22 February 2017

Modification Assessments – Planning Services  
Department of Planning & Environment  
GPO Box 39  
**SYDNEY NSW 2001**

**Combined comments on the proposed amendments to the modification of the Cobaki Concept Approval (MP06\_0316 Mod 5) and the proposed modification of the Project Approval (MP08\_0200 Mod 4) with regard to water supply and waste water treatment.**

Figure 5.9.1: Typical services section

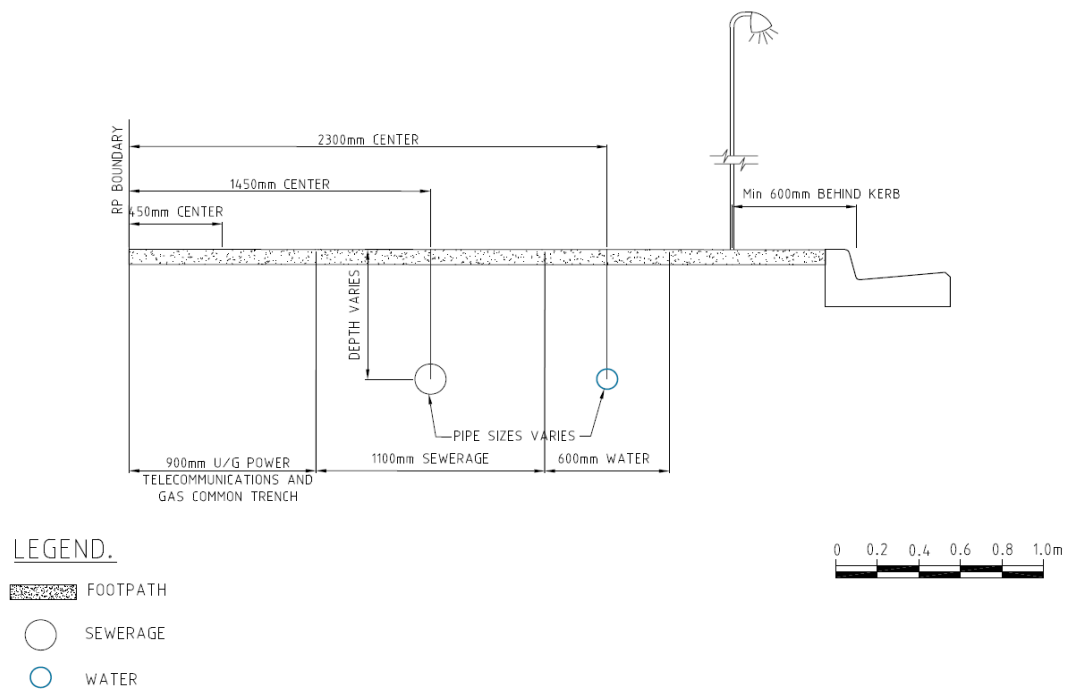
- a. Council's standard (and the current Development Code) specifies a 14.5m road reserve for Local Roads within Cobaki, consisting of 7.5m sealed pavement and 3.5m verges. The latest proposal widens the verge to 4.25m, but has maintained the same road reserve. This has reduced the road pavement to 6.0m, which is not supported.

- b. The provided Typical Section does not show the required 1.2m footpath on at least one side of the street.
- c. The Pressure Sewer Main needs to be a minimum 300mm below the Recycled Water main.

- d. A minimum clearance between proposed Pressure Sewer Main and Communications & Electricity compliant with WSA requirements needs to be specified for Council's further consideration.

- e. Council requires a minimum 3.0m wide easement if the sewer main is to become a Council asset. The main should also be located centrally within the easement.

- f. Council questions whether the proposed 2.0m wide PSU Easement is wide enough. Has provision for a control box/power meter been considered within the easement? Further detail / clarification is required in this regard.

- g. The Section needs to clearly specify the horizontal and vertical clearance between the proposed Potable Water main and Communications & Electricity, compliant with WSA requirements. Please document the Section accordingly.

- a. The proposed Collector Road needs to be re-labelled "*Low Volume Neighbourhood Connector Road*" as per the previously submitted "draft Access Network Plan and Potential Bus Route" for Mod 4 of the Concept Plan.
- b. The submitted Typical Cross Section references a Road Reserve width of 19.0m, however the submitted "draft Access Network Plan and Potential Bus Route" associated with Mod 4 of the Concept Plan, plans associated with approved DA15/1026 and the current proposed subdivision for DA16/0056 all reference an 18.5m Road Reserve, as per Council's standard .

- c. The submitted Section shows one 1.2m footpath. A "*Low Volume Neighbourhood Connector Road*" requires one 1.2m footpath and one 2.5m shared cycleway / footpath either side of the street. Plans should be amended accordingly.

- d. It appears that insufficient horizontal clearance is provided between the proposed Recycled Water main and the street light.
- e. It is considered that insufficient horizontal separation is proposed between the Recycled Water main and the Pressure Sewer Main. WSA07-2007 Pressure Sewer Code requires 1000mm separation. Plans should be amended accordingly.

- f. The Pressure Sewer Main needs to be a minimum 300mm below the Recycled Water main.
- g. Council requires a minimum 3.0m wide easement if the sewer main is to become a Council asset. The main should also be located centrally within the easement.

- h. Council questions whether the proposed 2.0m wide PSU Easement is wide enough. Has provision for a control box/power meter been considered within the easement? Further detail / clarification is required in this regard.
- i. The Section need to clearly specify the horizontal and vertical clearance between the proposed Potable Water main and Communications & Electricity, compliant with WSA requirements. The offset is also a function of the pipe diameter. Please document the Section accordingly.

- a. The proposed Distributor Road needs to be re-labelled "*Normal Neighbourhood Connector Road (Sandy Road)*" as per the previously submitted "draft Access Network Plan and Potential Bus Route" for Mod 4 of the Concept Plan.

- b. The submitted section shows one 1.2m footpath. A "Normal Neighbourhood Connector Road (Sandy Road)" requires one 1.2m footpath and one 2.5m shared cycleway / footpath either side of the street. Plans should be amended accordingly.

- c. Council advise that it is not a desirable outcome to have the water supply main located within the Central Median of Sandy Road, as proposed. However, it is considered a better outcome than locating the water supply main under a trafficable pavement or footpath. The proponent is requested to clarify whether this infrastructure is intended to become Council's asset or NWS', depending upon the location of the proposed bulk meter if WIC Act infrastructure is approved.

- d. It appears that insufficient horizontal clearance is provided between the proposed Recycled Water and the street light.
- e. It is considered that insufficient horizontal separation is proposed between the Recycled Water main and the Pressure Sewer Main. WSA07-2007 Pressure Sewer Code requires 1000mm separation. Plans should be amended accordingly.

- f. The Pressure Sewer Main needs to be a minimum 300mm below the Recycled Water main.
- g. Council requires a minimum 3.0m wide easement if the main is to become a Council asset. The main should also be located centrally within the easement.

- h. Council questions whether the proposed 2.0m wide PSU Easement is wide enough. Has provision for a control box/power meter been considered within the easement? Further detail / clarification is required in this regard.

- a. Subsoil drainage
  - i. The subsoil drain is shown behind the kerb and only on one side. The subsoil drain is required on both sides of the road pavement and under the kerb, as per TSC SD.001 & SD.012. Sections are to be amended accordingly.
- b. Street Trees
  - i. All street trees must plantings must meet at least the minimum requirements specified in TSC Standard Drawing 701 Tree and Shrub

- a. Detailed Typical Cross Sections (similar to that provided for non WWTP serviced roads) are required for all road profiles proposed to contain WWTP services (i.e. the 40m Road Reserve Cobaki Parkway, the 22.4m Road Reserve "Normal Neighbourhood Connector Road (Sandy Road)" and the 18.5m (Road 4) Road Reserve "Low Volume Neighbourhood Connector Road". These sections must also detail all other applicable infrastructure for that section (i.e. kerb, subsoil drainage, gas, stormwater, street trees, street lights, footpaths, electricity, easements, etc). All horizontal and vertical offsets are to comply with the applicable WSA requirements.

- b. The placement of dual mains one directly above another, albeit for the same purpose, is considered to be poor practice and is contrary to the recommendations of the various WSA Codes:

- iii. WSA 07-2007 Table 3.1 specifies minimum 600mm clearance to other sewers but does not specifically mention pressure sewers.
- c. There appears to be a discrepancy between the sizes of Mains pipes in the Service Corridor diagram in Figure 5.9.2 to the pipe sizes that are shown on the Drawing 1014 (provided to Council separately – see attached).

- i. Dwg 1014 shows 2 x 450 DW Trunk Mains whereas the Section shows 2 x 300 Drinking Water mains.
  - ii. Dwg 1014 shows 2 x 450 RW Trunk Mains whereas the Section shows 2 x 300 Recycled Water mains.

- iii. Dwg 1014 shows a DN225 Water Supply Main whereas the Section shows a 375 Drinking Water Supply Main.
